Date: December 6, 2022

Project: Vue De La Parc

Location: 0 S. 8th Street  
Colorado Springs, CO 80905

## Public Comment Responses:

GENREAL INFORMATION

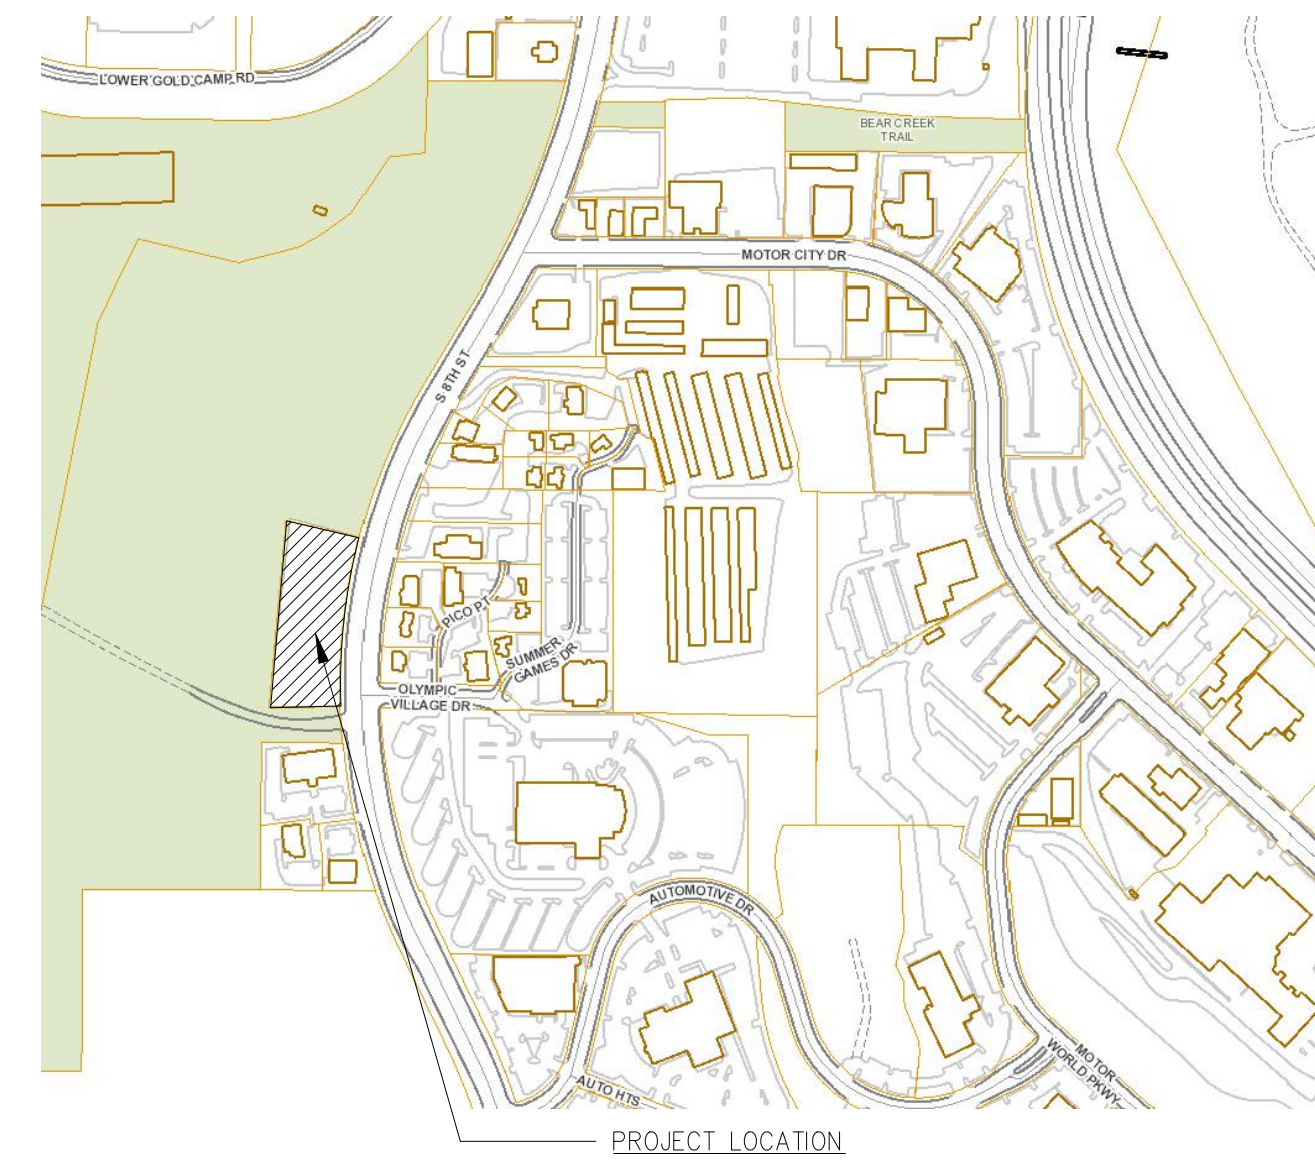
3. The Architectural Plans indicate that the only Lighting on the Property would be low mounted full cut off bollards. We would assume that there are additional building mounted lights however not indicated. As this property backs up to Bear Creek Park and is located on the Hill, special care will need to be taken to specify low lumen full cut off Light fixtures that do not trespass beyond property line and disturb the Parks Wildlife. This should be addressed in the Development plan.

VUE DE LA PARC
DEVELOPMENT PLAN
PRELIMINARY GRADING

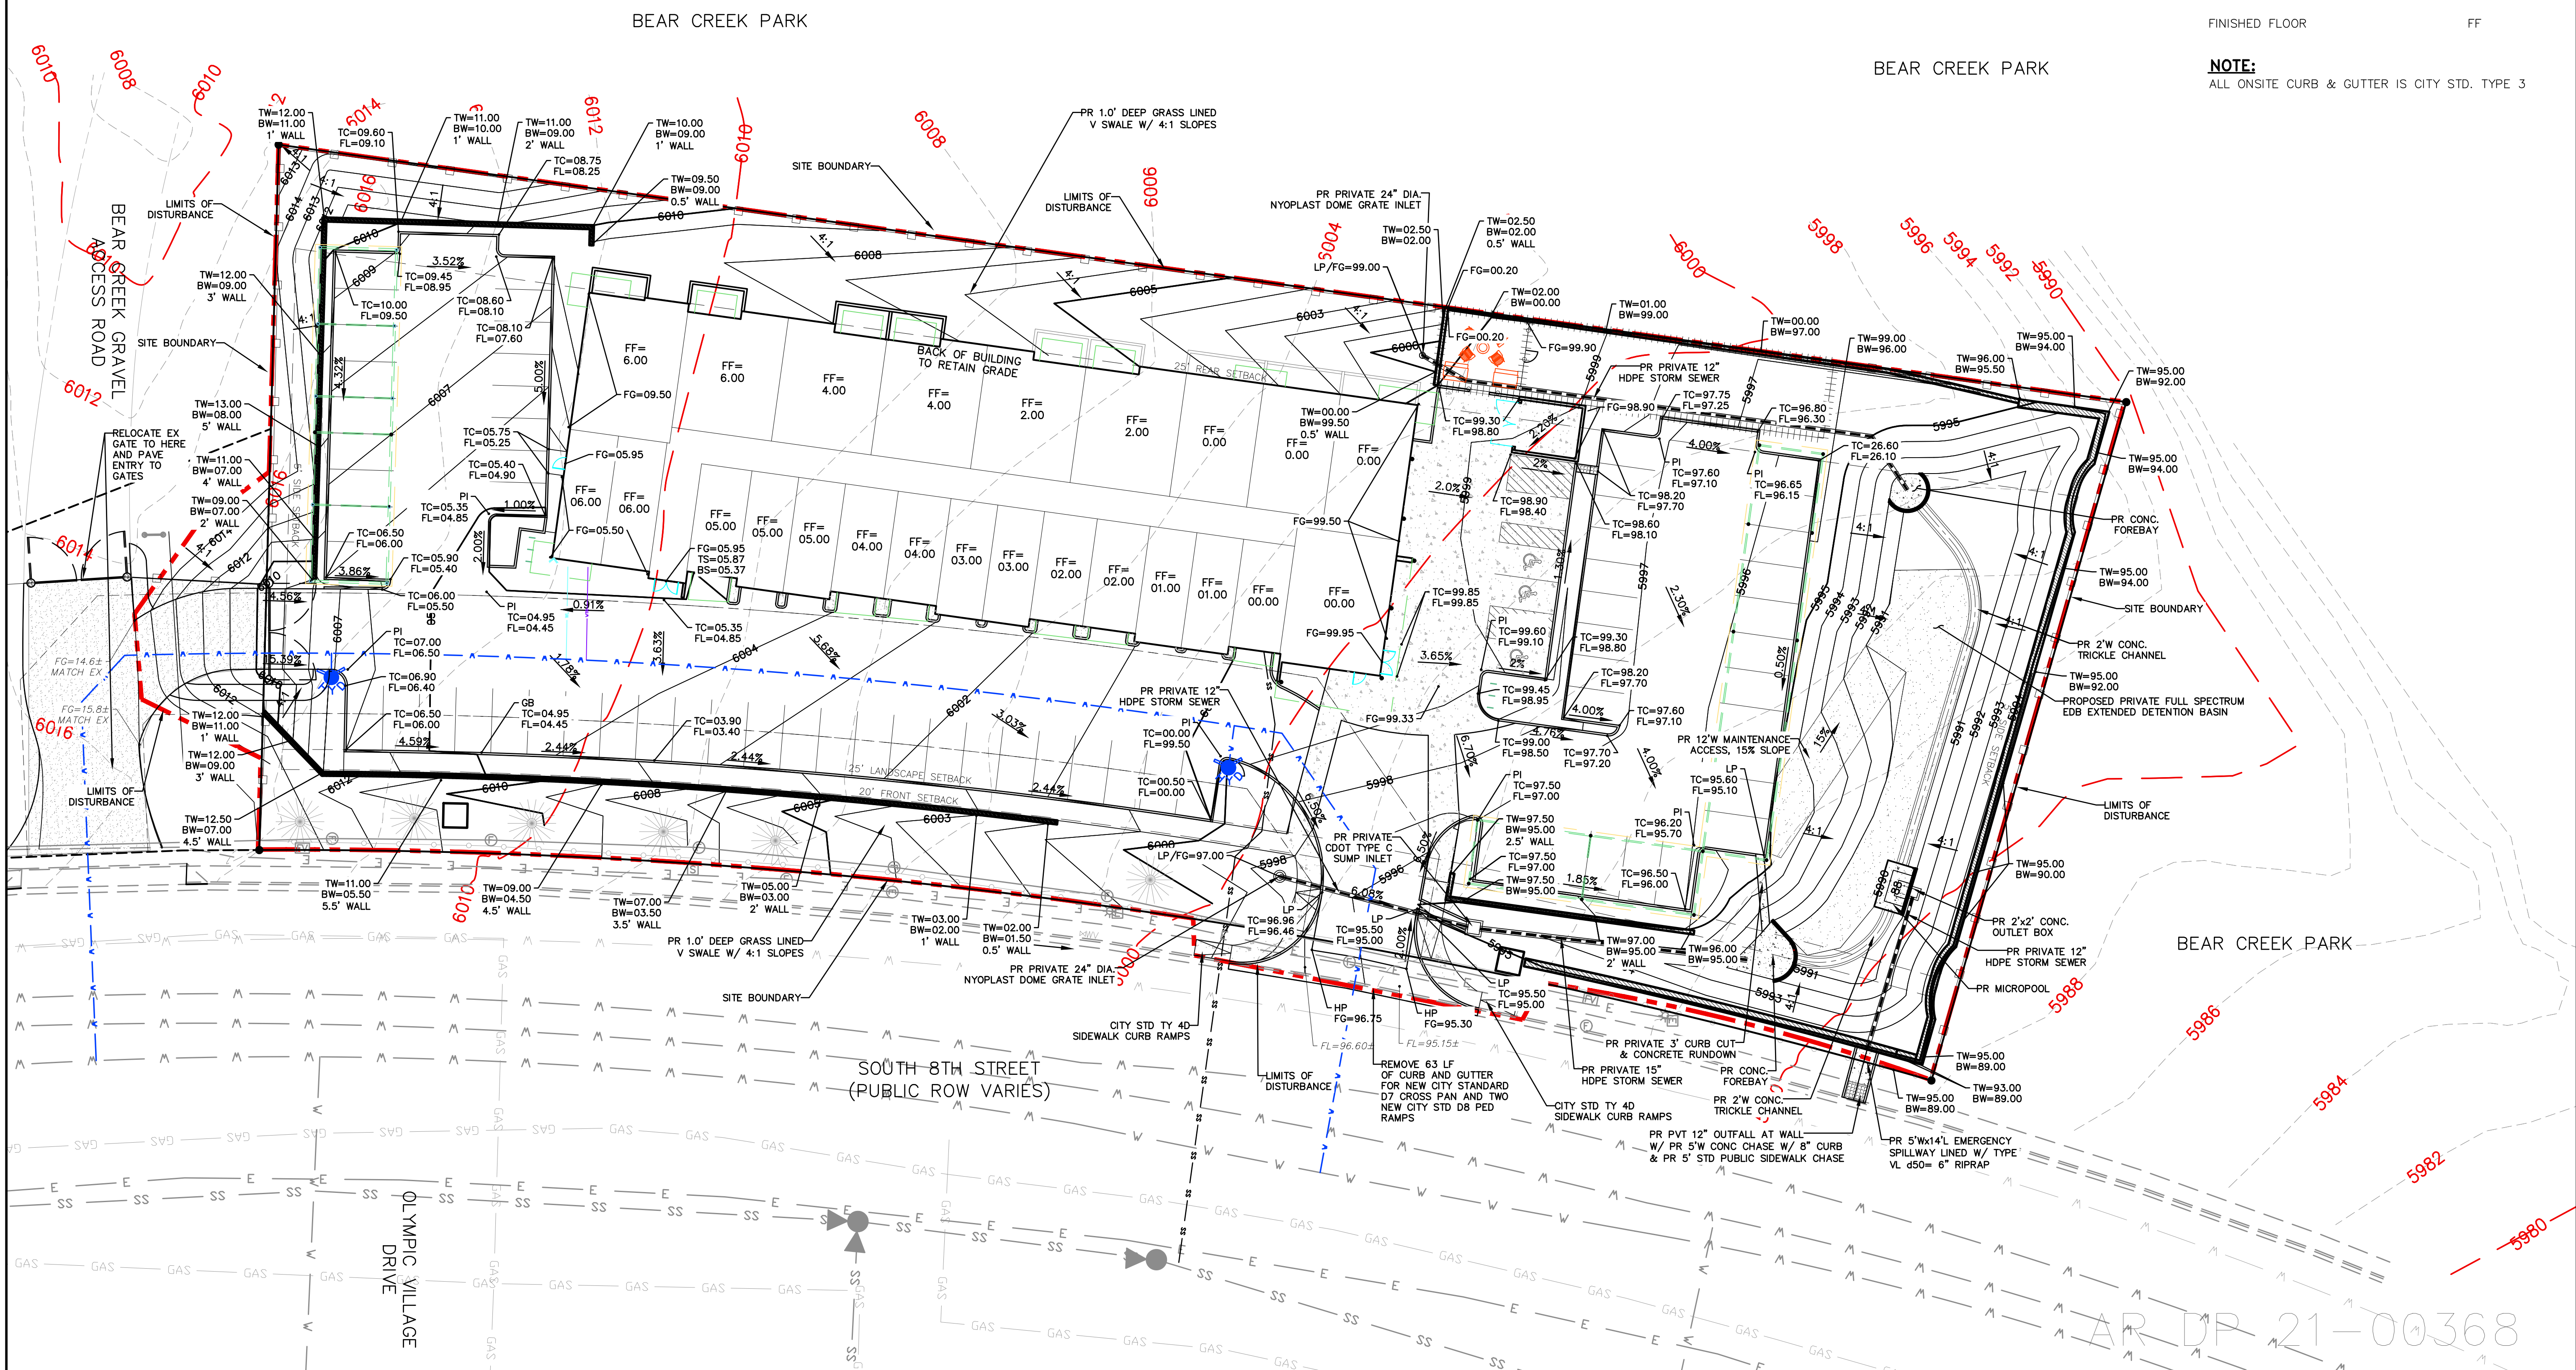
1. 8th Street’s underground springs were not reflected on the resubmittal plans. These caused years of agony for both building and business owners due to heavy build-up of ice at the bottom of their driveways. There were many close calls that could have had severe outcomes. Due to many years of persistence by the Building Owners and with the help of KRDO, we may finally have gotten the issue resolved last year. The city bored 8th Street at the corner of Olympic Village Drive and installed a 10” pipe to divert the water to the west side with the idea that there was more sunlight and no developed property and driveway that would be affected by the new drainage system. Note this drainage system terminates in proximity to the proposed development project property. This issue is not addressed in any of the development plans although this most certainly would have to be addressed so as not to create another hazard.

1. Part of the proposed development includes a large stormwater detention pond. This will be a net improvement for the areas stormwater management.
2. The parking proposed on-site exceed the amount required by the City. Any cars parking illegally off-site will be handled by the City Police. This development is close to public transit and trail systems and we anticipate that the parking provided on-site will be more than sufficient to meet the demands of the development.
3. Special care will be taken in the lighting. As you noted the parking lot lighting has been minimized, building lighting will be equally thoughtful.
4. The Administrative Relief criteria were submitted to the City in May of 2021. These have been attached to this response letter.
